A46 Newark Bypass

Scheme Number: TR010065

**Statement of Common Ground
with Nottinghamshire County Council**

February 2025

FARNDON UNDERPASS

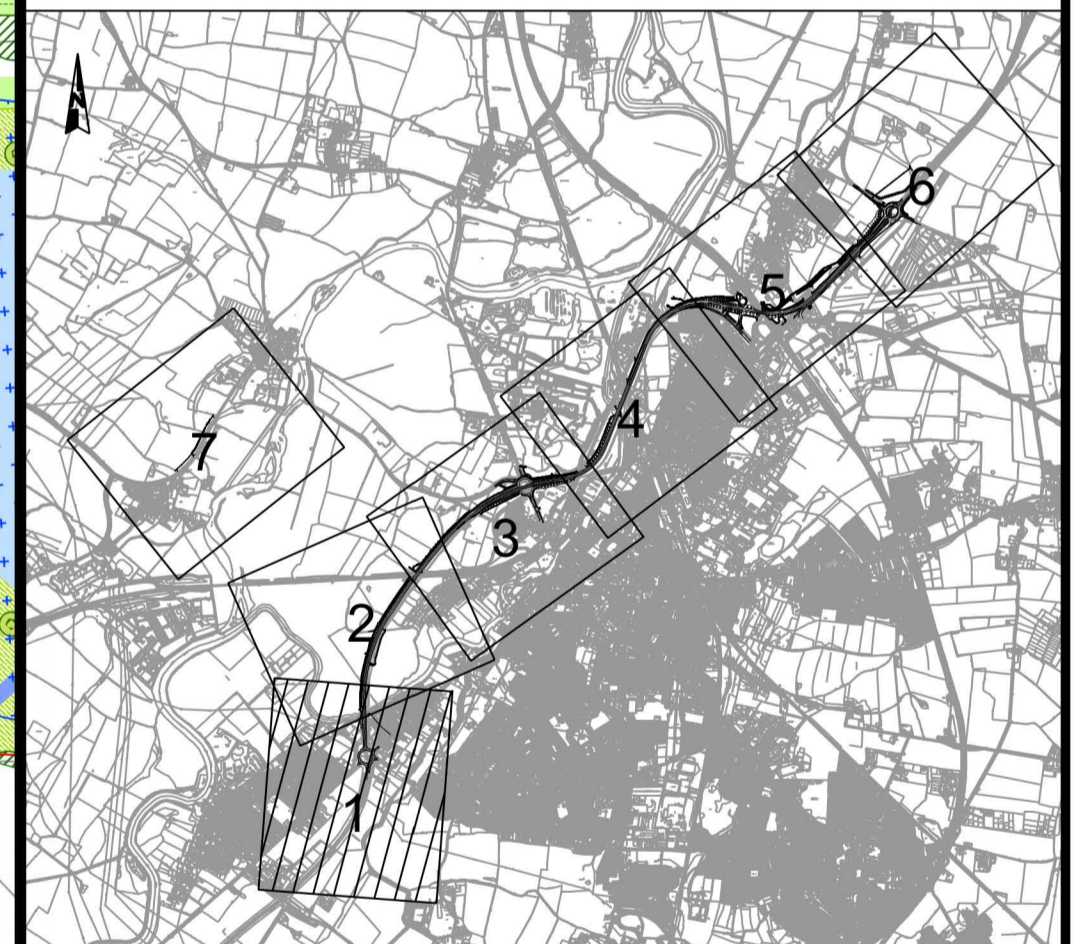
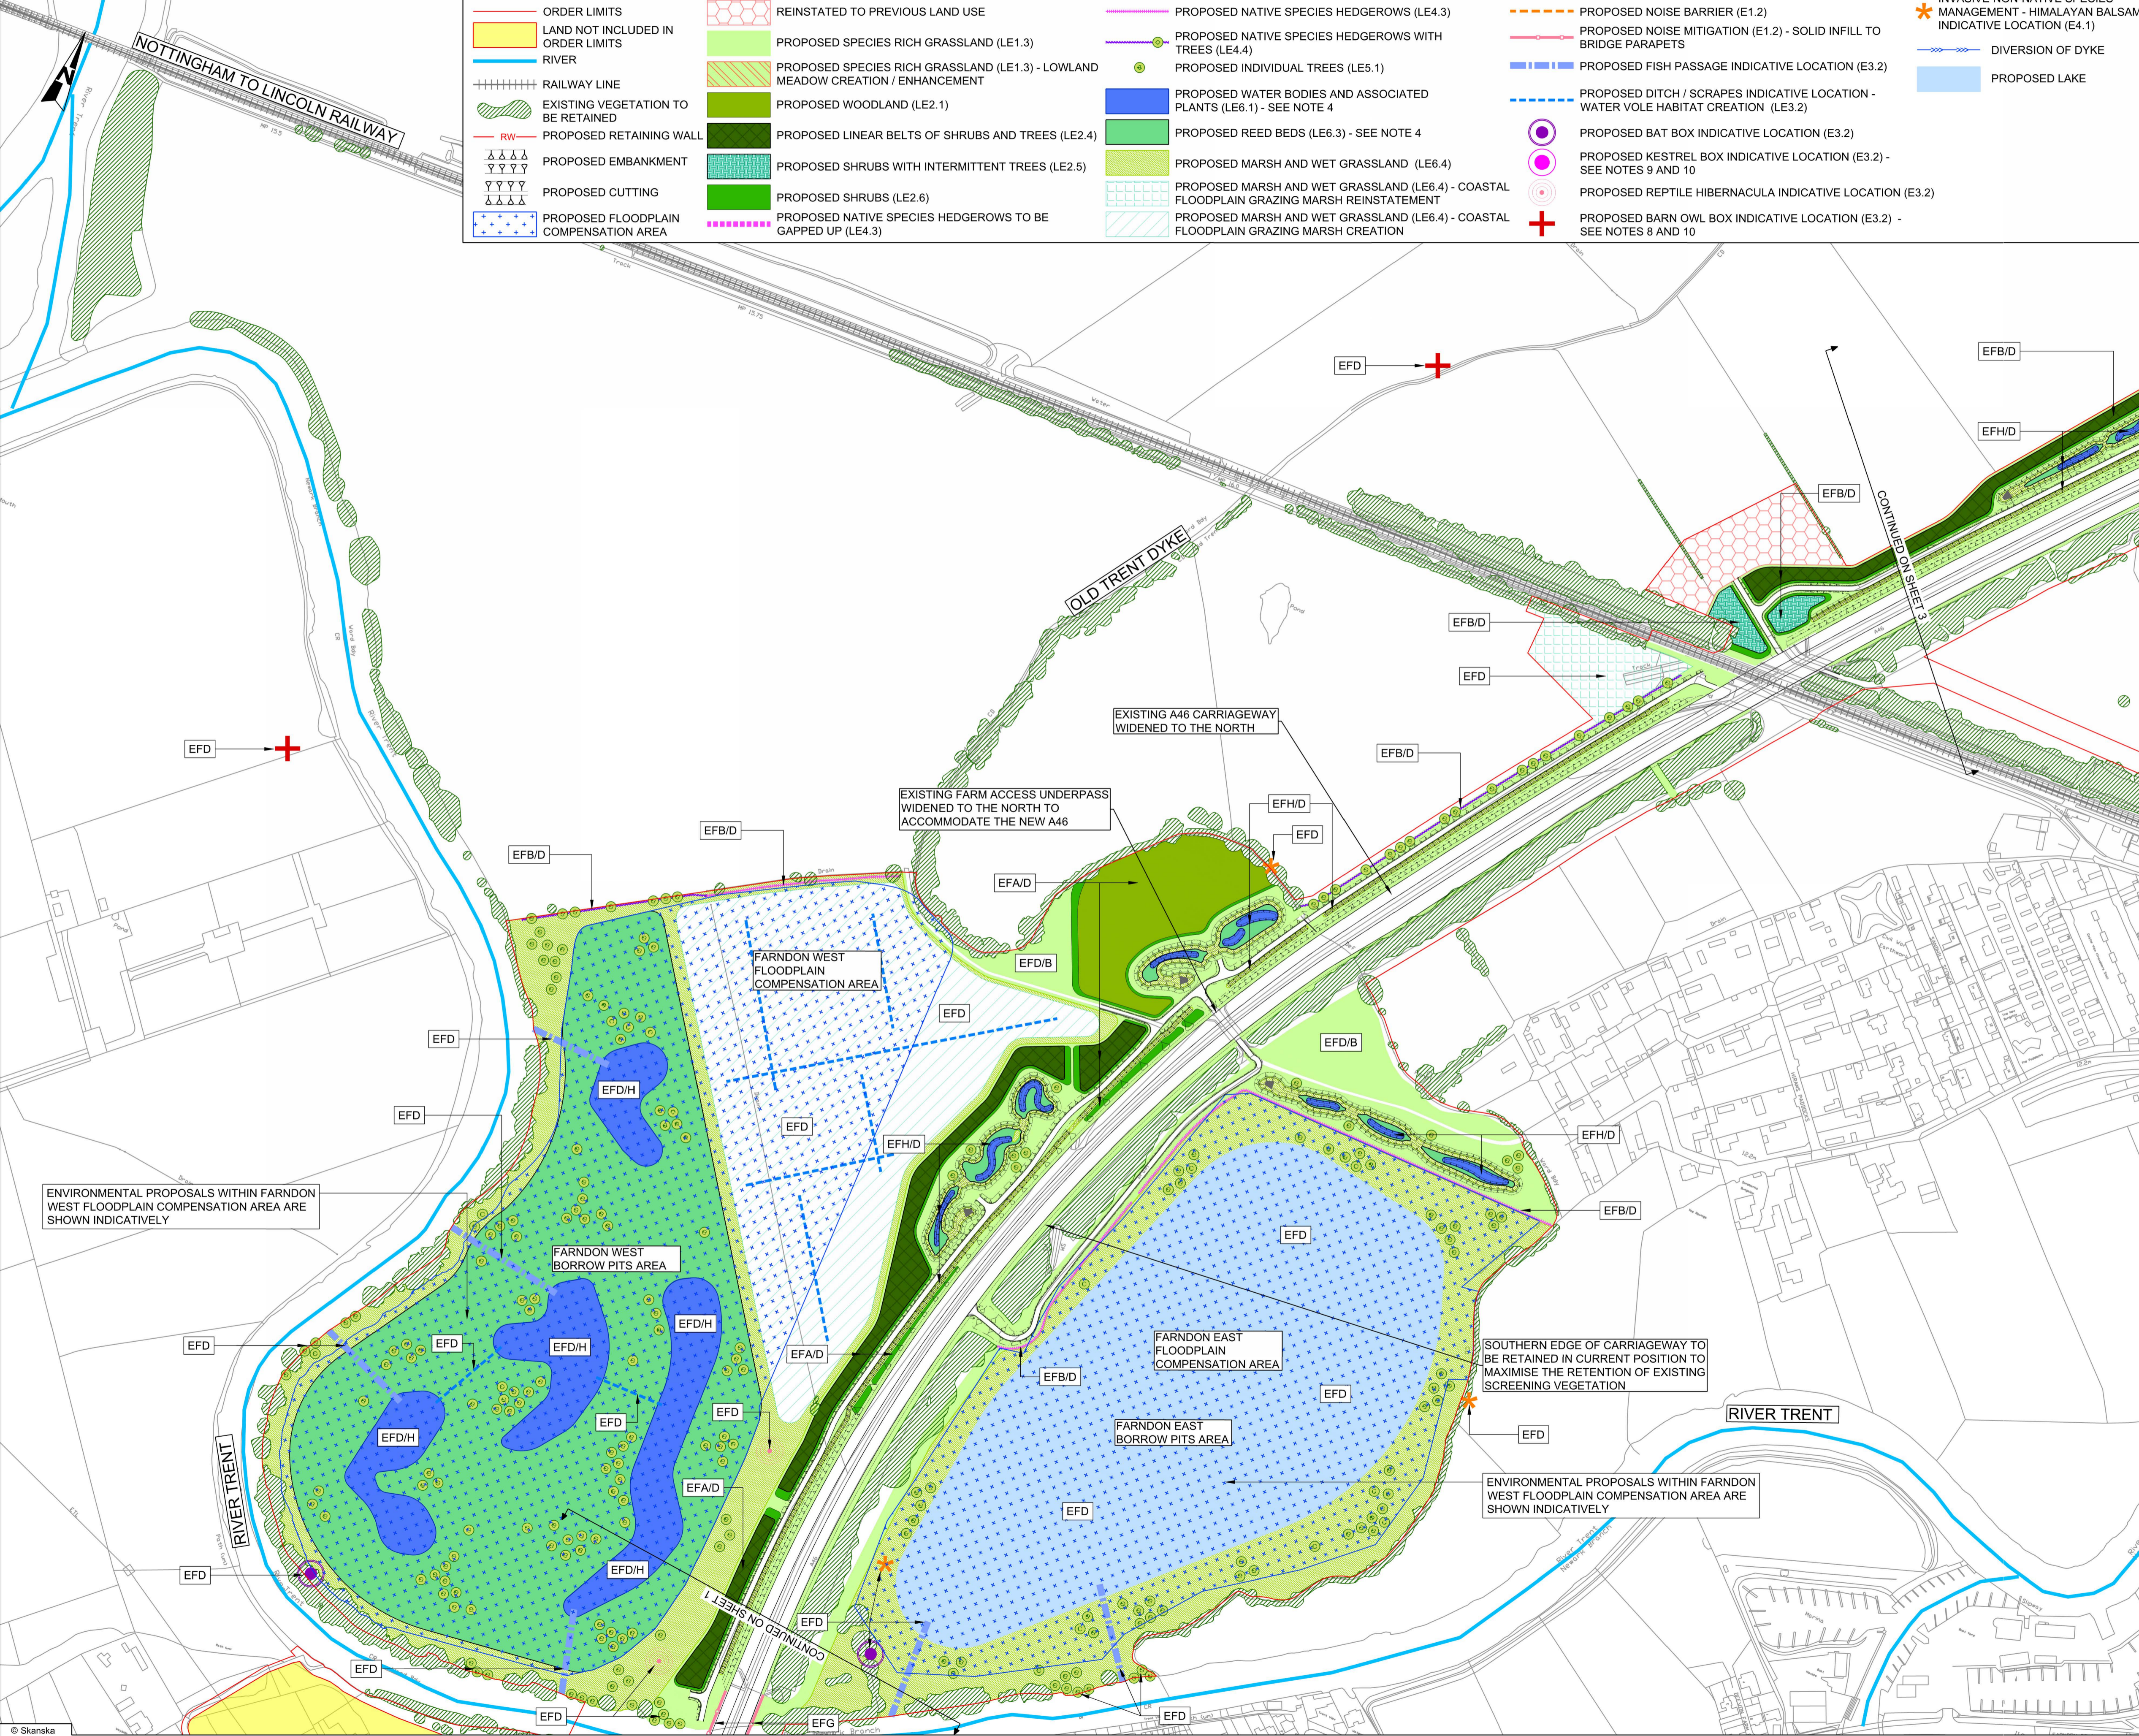
5.	PRoW		Farndon A46 roundabout The plans indicate that the Farndon Underpass will remain open throughout the works which is good. As you are aware the land adjacent to Crees Lane is currently used by members of the public as a walking route, we are also aware that National Highways are planning to use this as a compound. We would support the opportunity to create a public footpath at this location to link the underpass with Footpath No.5 and Bridleway No.2. Farndon A46 roundabout - the land which is set out for the works compound adjacent to Crees Lane has a number of unrecorded desire lines through it. It would be advantageous to see these formally recorded and set out following completion of the Scheme.	Following feedback received as part of the statutory consultation, the temporary diversion of bridleway BW2 was changed, and an alternative route was presented as part of the targeted consultation on the Scheme between 14 March and 16 April 2023. Following further feedback received as part of the targeted consultation the temporary diversion of the bridleway will be only for use by equestrians. Pedestrians and cyclists will utilise the existing footpath FP5 from the River Trent to gain access to the route adjacent to Crees Lane shown within the Order Limits. The unrecorded desire lines are on a piece of land that has been identified for temporary use as part of Scheme, any activity to formally record these desire lines as Public Rights of Way would need to be undertaken by stakeholders, including NCC, outside of the Scheme.	Agreed	04/11/2024
